Thank you for providing the "Re-alignment of Gas Main - Consent SSD\_5093 (Mod 1) - Response to Submissions" dated September 2015 (**Response**).

In regards to section 2.2 of the Response, Ausgrid's concerns have been addressed, given that the proposed pipeline alignment along the Wicks Rd frontage:

FIGURE 2 – PLAN OF PROPOSED GAS MAIN RELOCATION (REFERENCE: C-0-9-20)

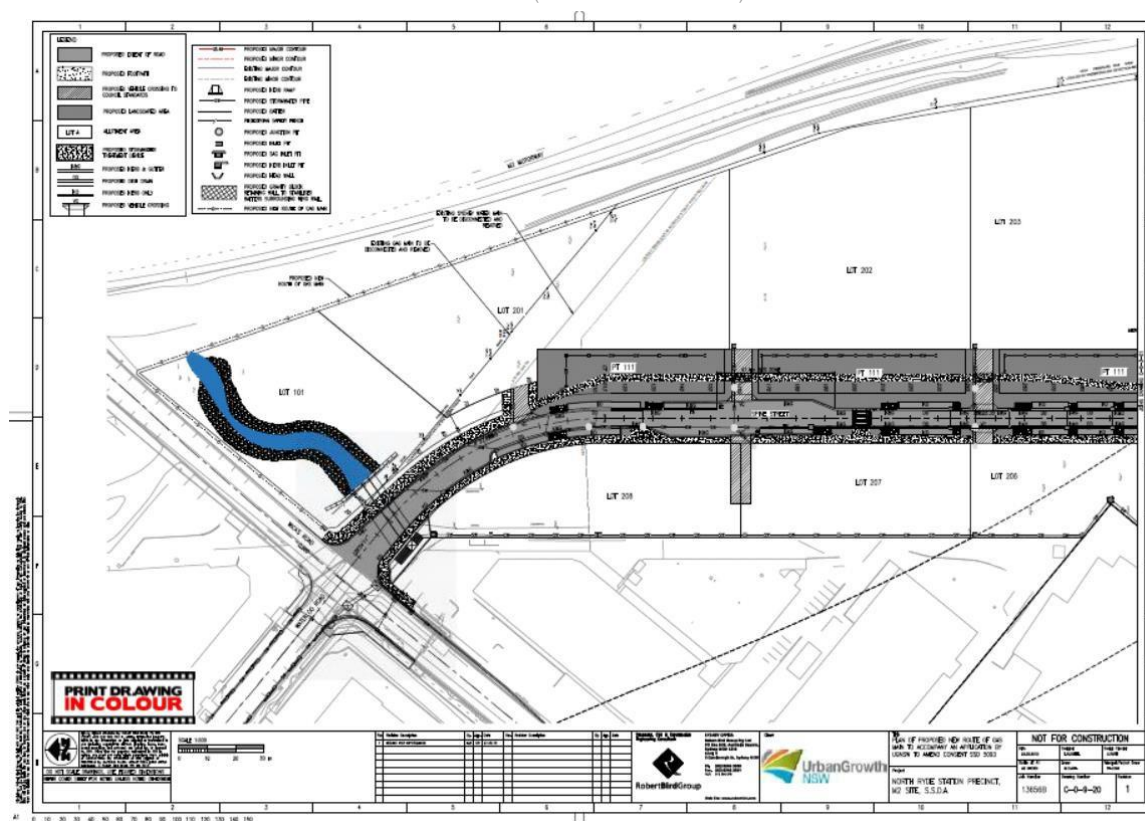
1. has been relocated within the property boundary;
2. has been amended as per Drawing Number C-0-9-20 Rev 4 (dated 31.08.2015); and
3. is consistent with the original approval in Consent SSD\_5093.
